Brad Saucier - 116 Walton St application

From: Marge Schmuckal
To: joe@whipplecallender.com
Date: 6/10/2013 2:18 PM
Subject: 116 Walton St application
CC: Brad Saucier

I am reviewing your application for 116 Walton Street. Please note that the last approved use was a two family. You are now changing from a two family to a single family handicap dwelling unit. There is a \$75 fee for a change of use. Please make arrangements with our front staff for payment.

1 Third Floor Plan
A1.4 SCALE: 1/4" = 1'-0"

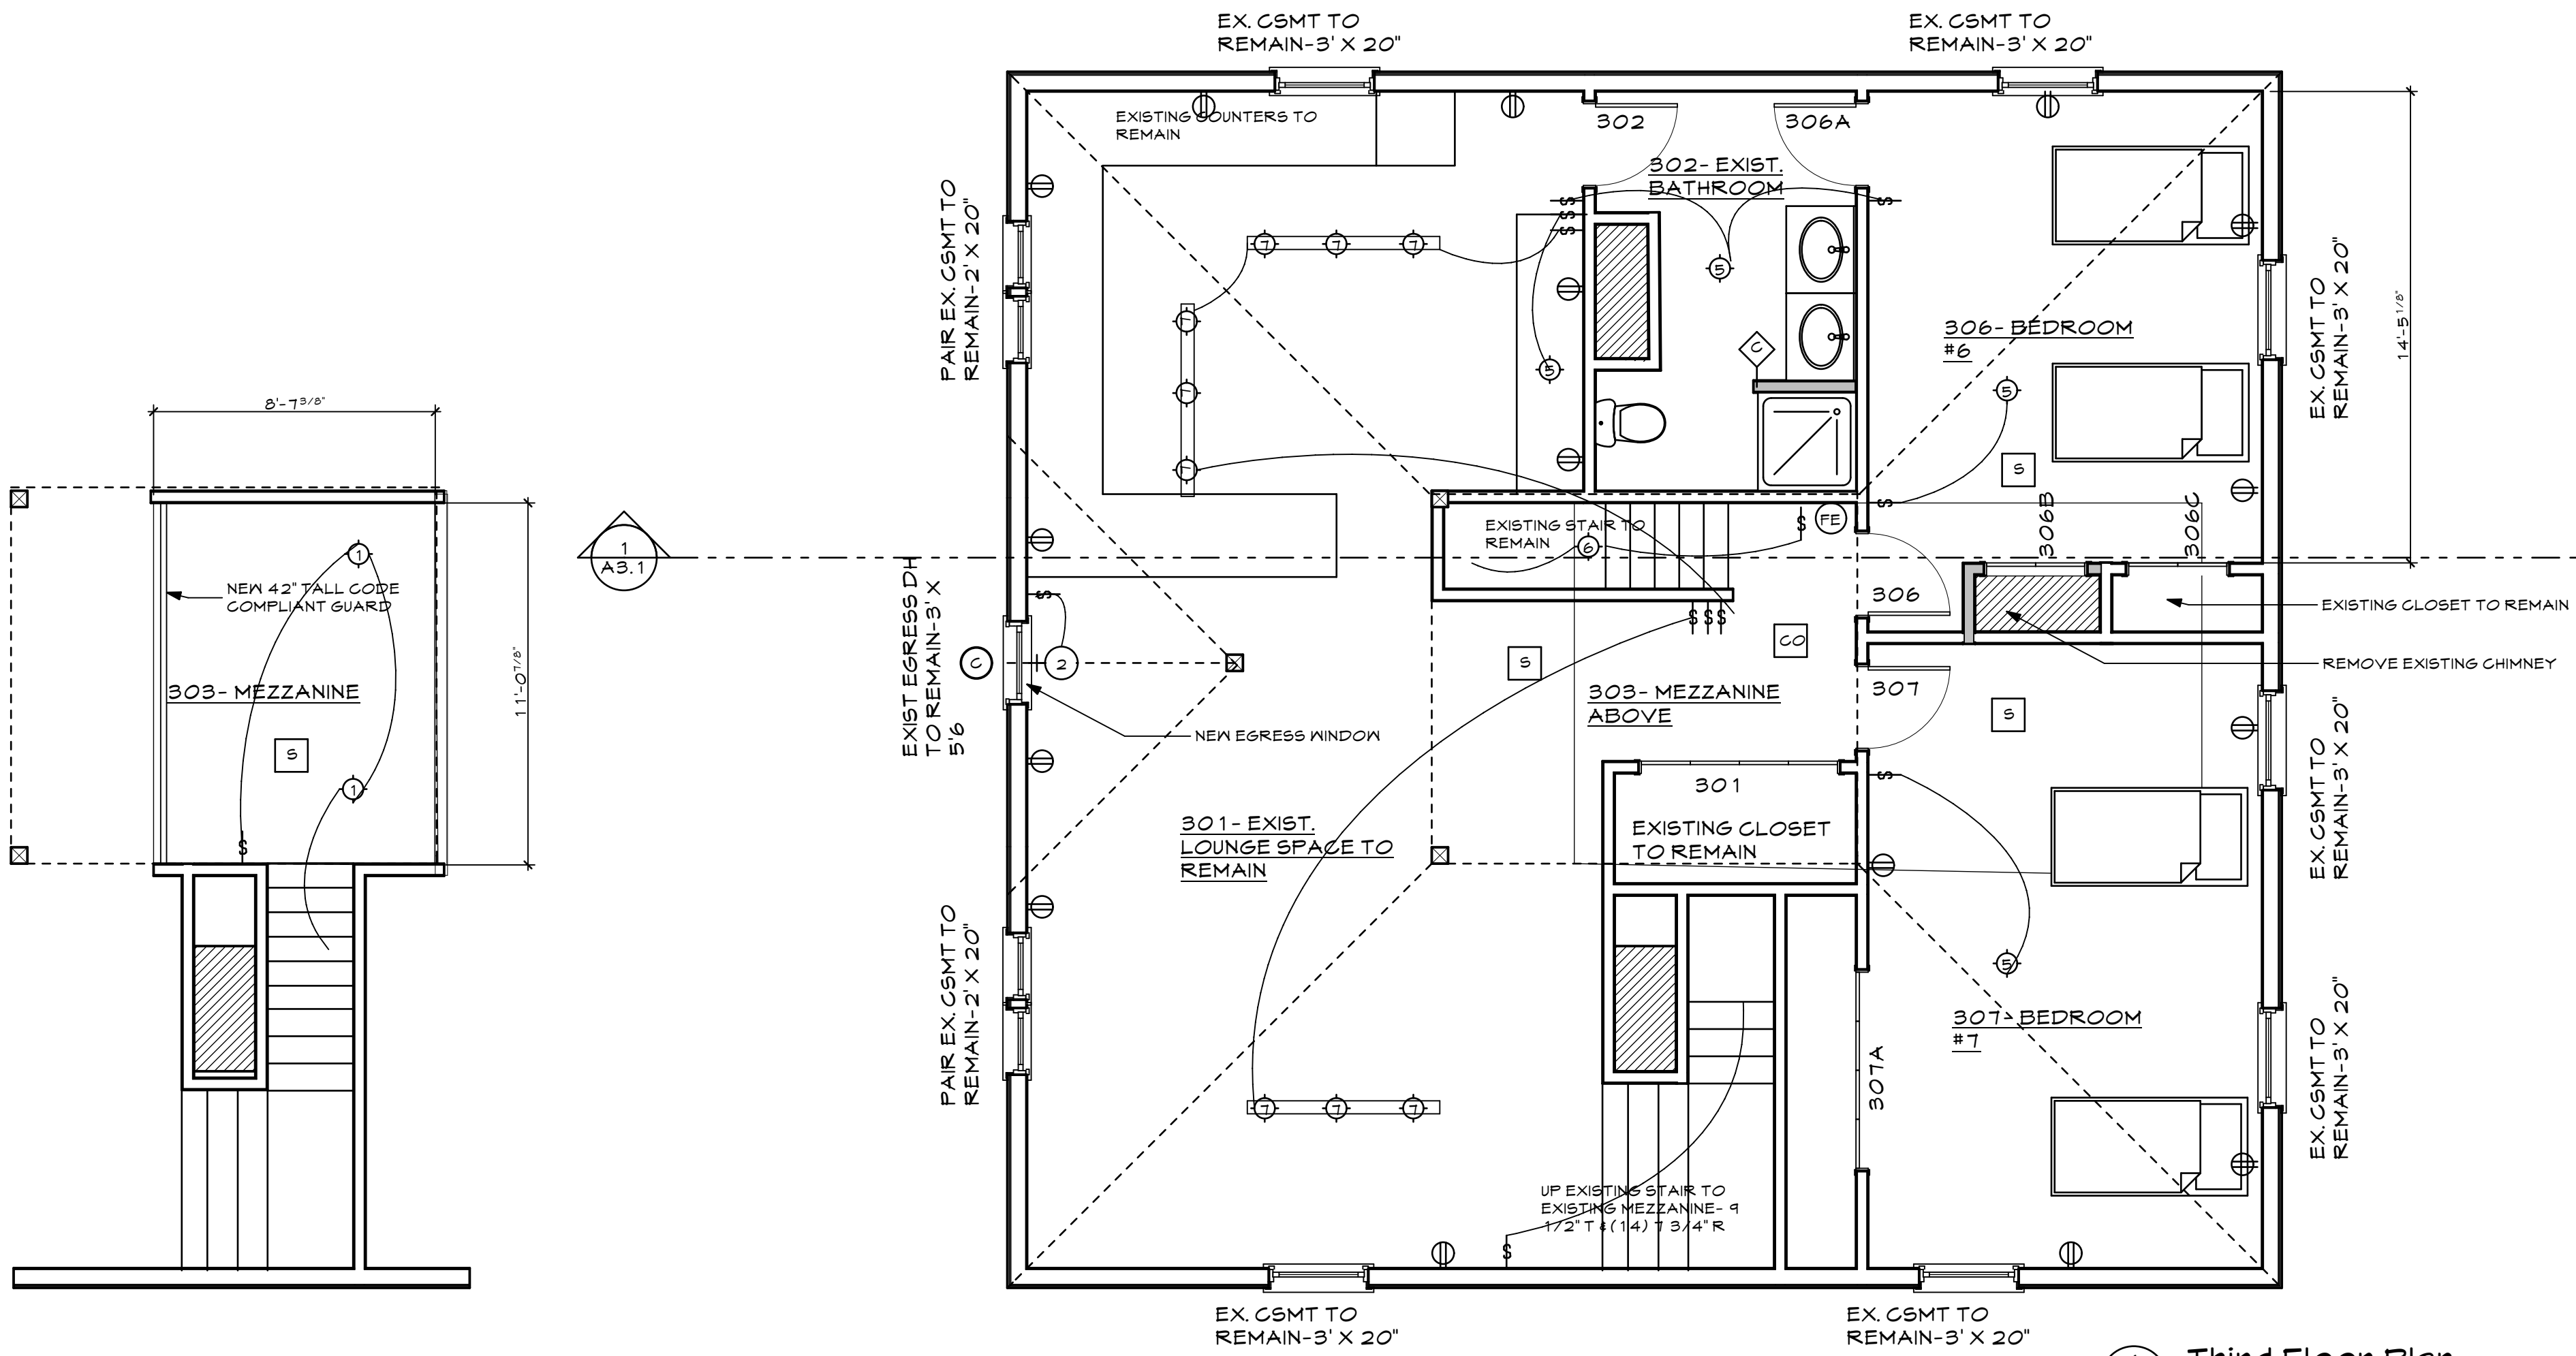
I am also counting 18 beds in the building. As you know, handicap family units do not allow more than 16 beds. Please revise your plans.

1 Detail 1 - site detail
 A6.2 SCALE: 1/2" = 1'-0"
 0 1 2 4

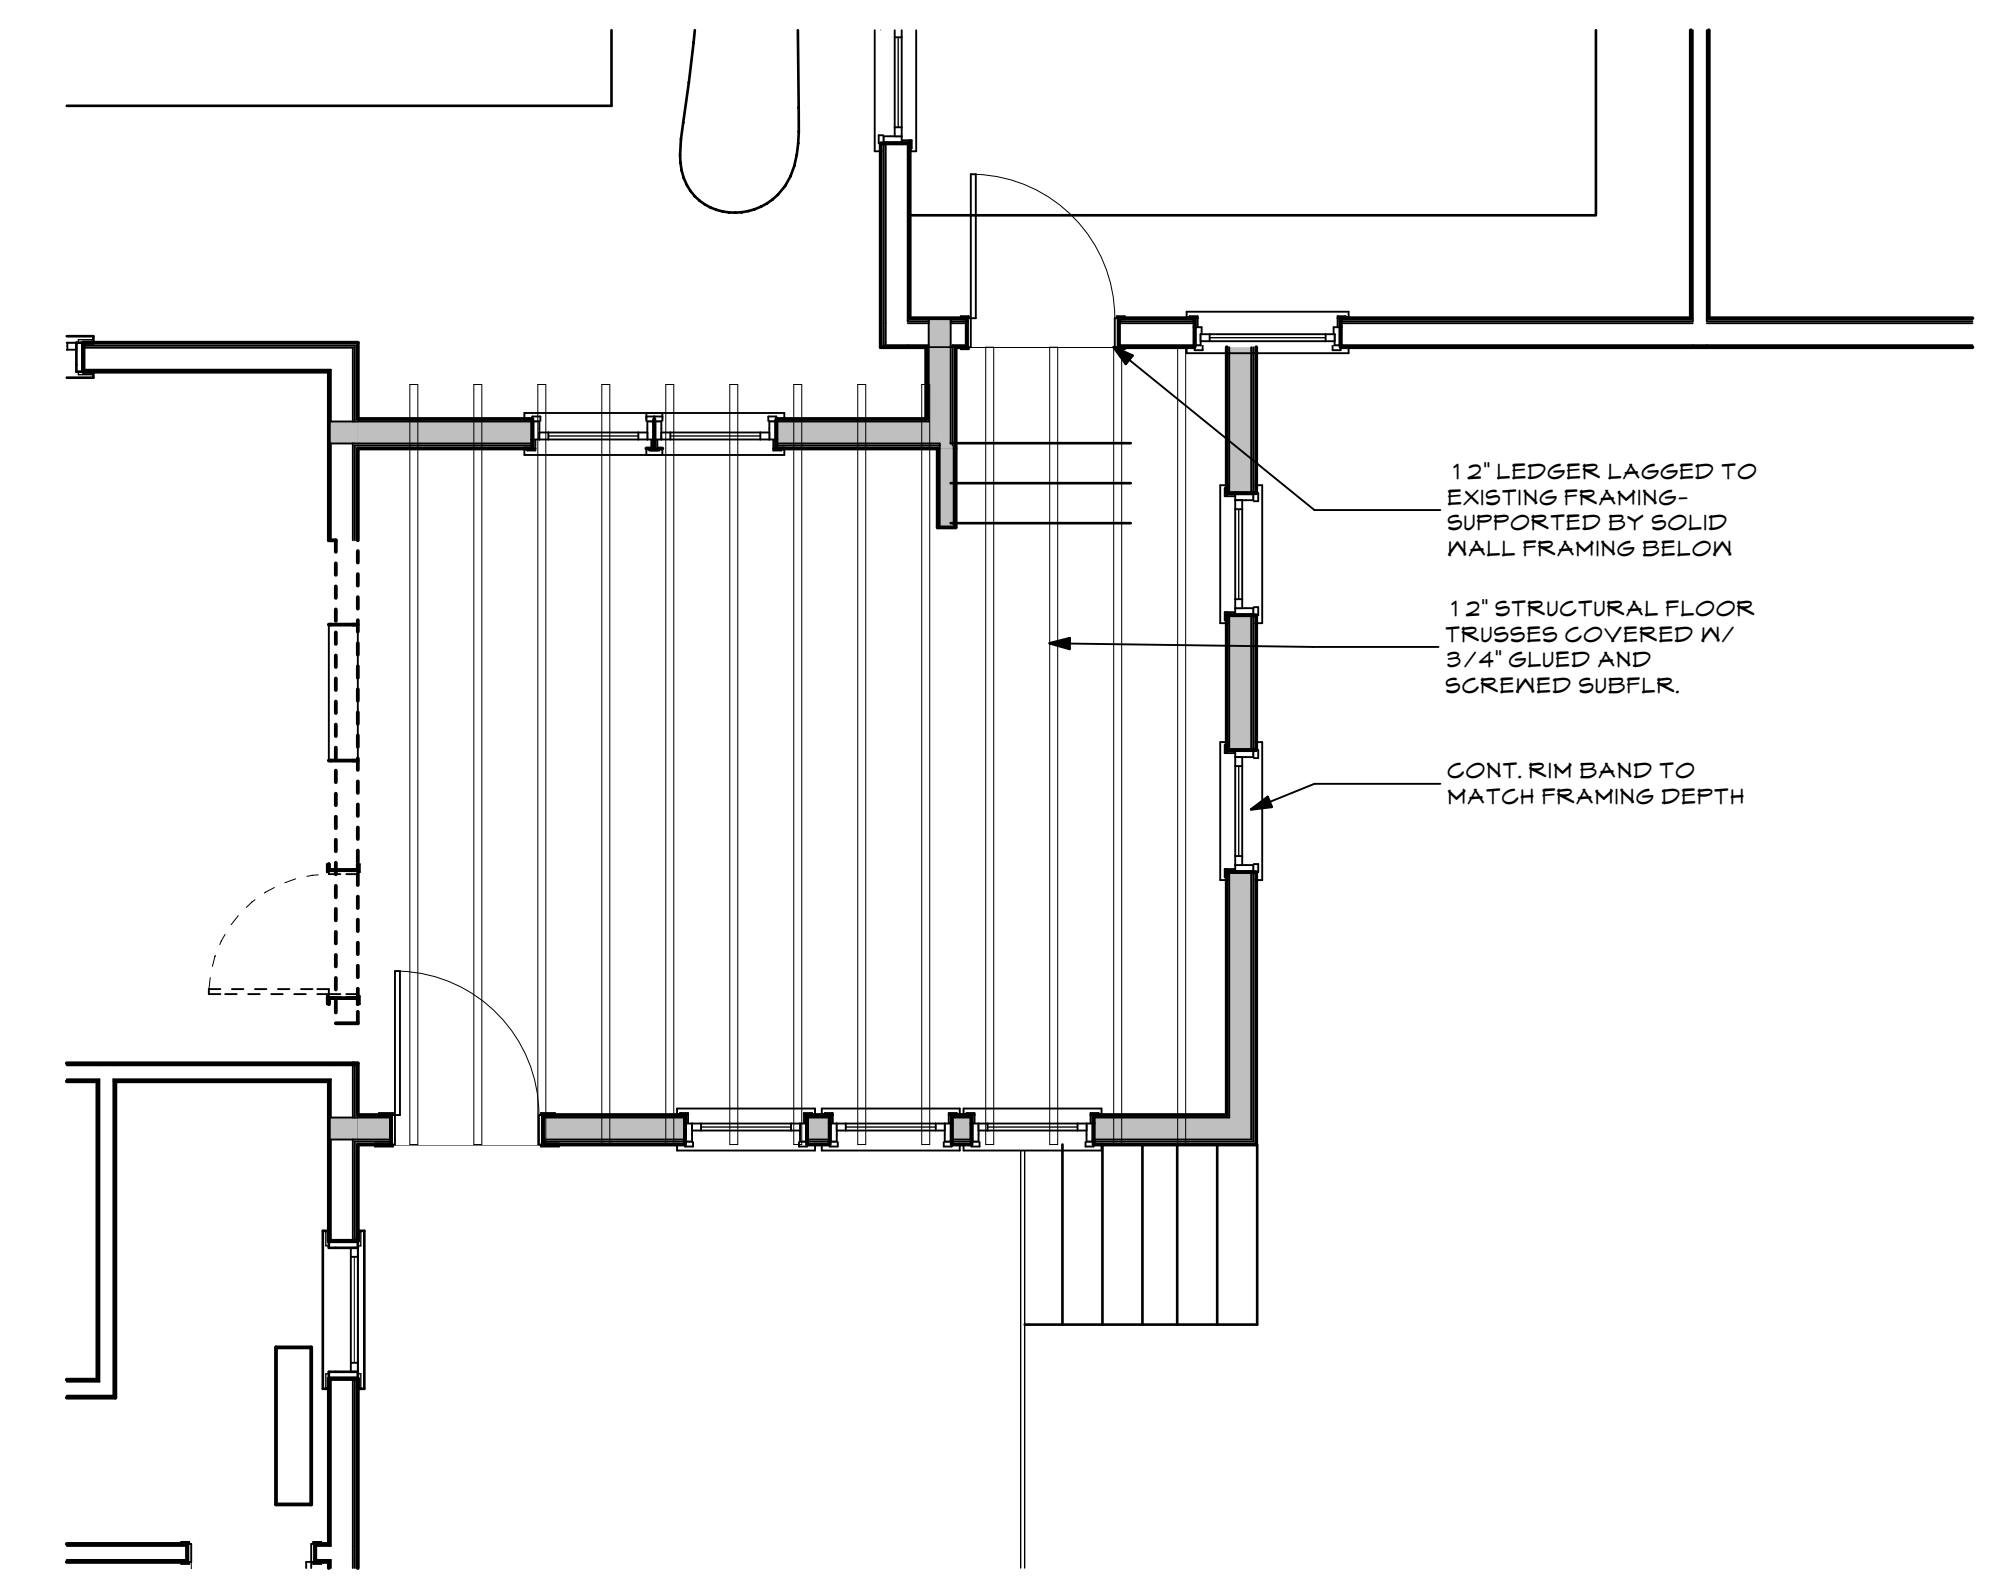
You will also need to revise your site plan to show the new bulkhead that is to be installed. Please remember that ALL projections from the structure must be shown on a site plan.
